Tween Bridge Solar Farm

8.2 Response to Relevant Representations

Document Reference: 8.2

Revision 1

Document Reference: 6.4.6.3

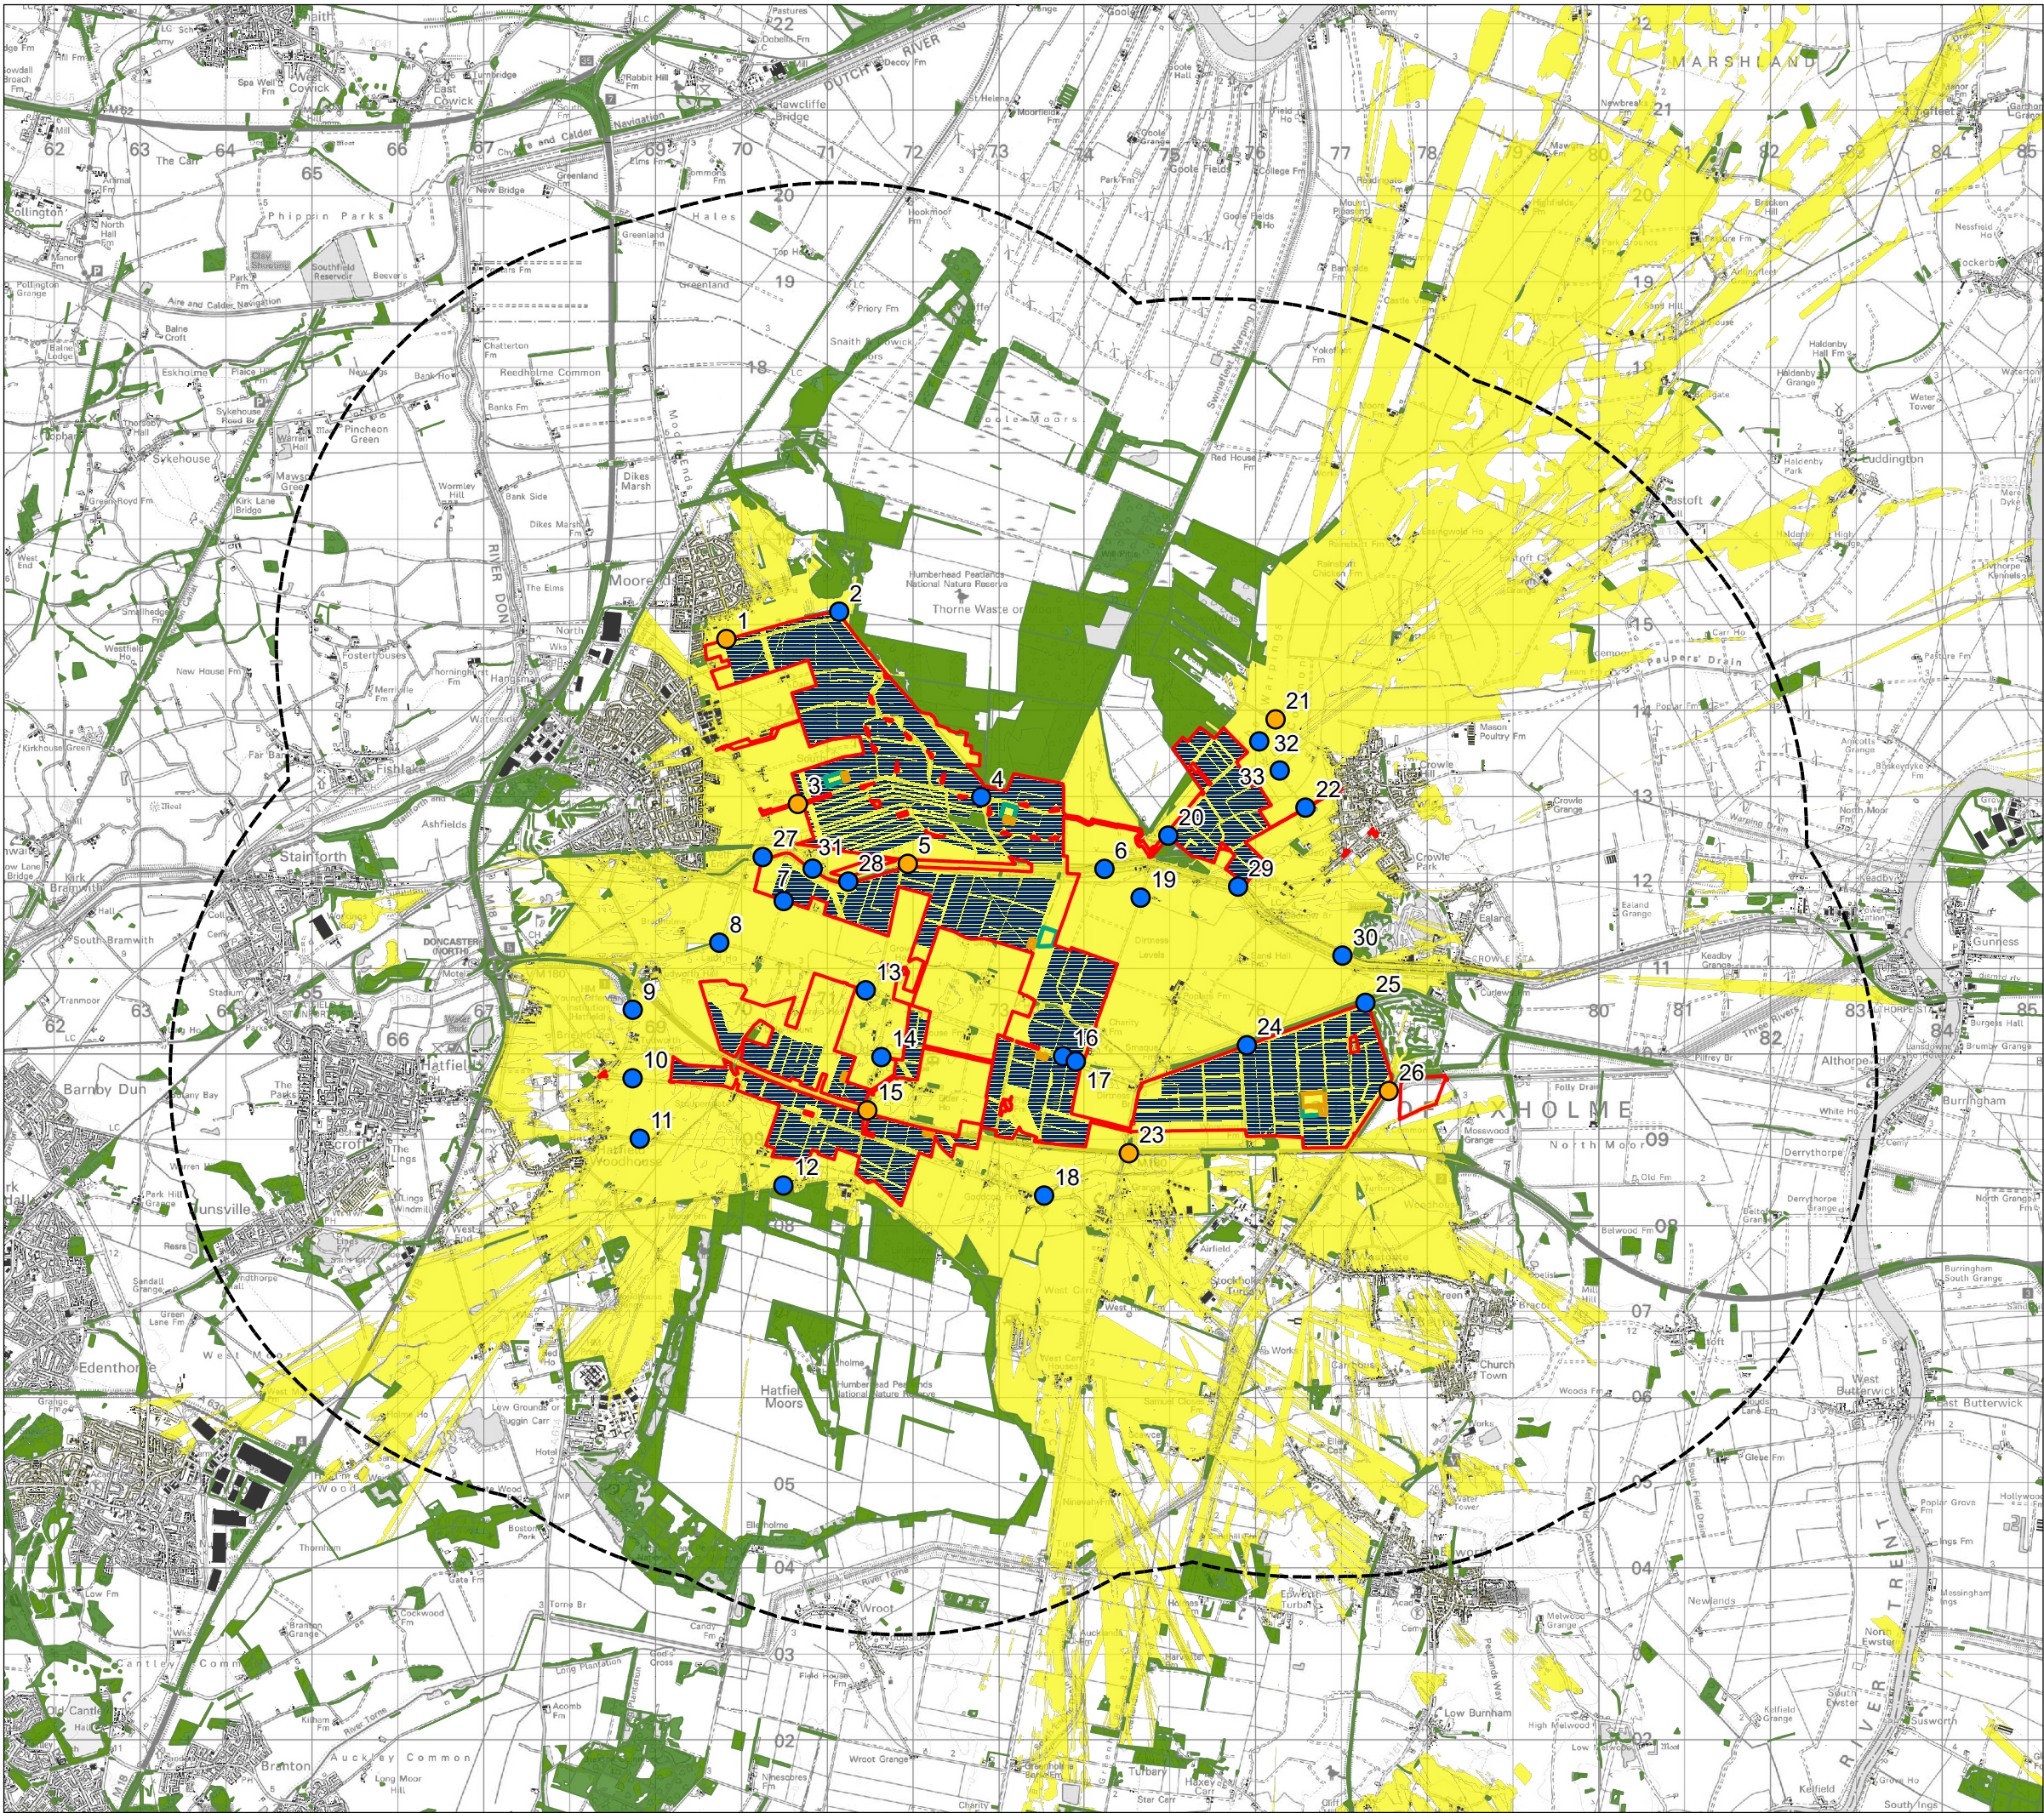
<p>6.3 In this respect, CDC notes that Figure 6.3 – Screened Zone of Theoretical Visibility with Viewpoints and Photomontage Locations [APP-147] indicates that there is limited visibility from Humberhead Peatlands National Nature Reserve due to extensive woodland vegetation and therefore, the Applicant considered that no detailed consideration was deemed necessary for this assessment. CDC would strongly question the Applicant's logic behind not including viewpoints taken from the Nature Reserve to evidence this position.</p>	<p>ES Figure 6.3: Screened Zone of Theoretical Visibility with Viewpoints and Photomontage Locations [APP-147] shows very limited visibility within both NNRs and any related public rights of way, (noting that both contain Access Land and promoted routes which also show very limited visibility). Viewpoints have been chosen on the periphery of the areas, on junctions with rights of way and permissive routes to illustrate a worst case scenario, namely Viewpoints 2, 4 and 20 on the southern edges of Thorne Moors and viewpoint 12 on the northern edge of Hatfield Moors.</p> <p>Table 6.4 of ES Chapter 6: Landscape and Visual [Document Reference 6.2.6 Revision 2] sets out the Viewpoint and Photomontage Locations, which in paragraph 6.4.62 are considered to provide representative views towards and in some cases from within the Order Limits from the surrounding landscape as illustrated on ES Figure 6.3 – Screened Zone of Theoretical Visibility with Viewpoints and Photomontage Locations [APP-147] and presented in Viewpoint Photographs in ES Appendix 6.3 – Viewpoint Photographs [APP-O63 – APP-O66].</p>
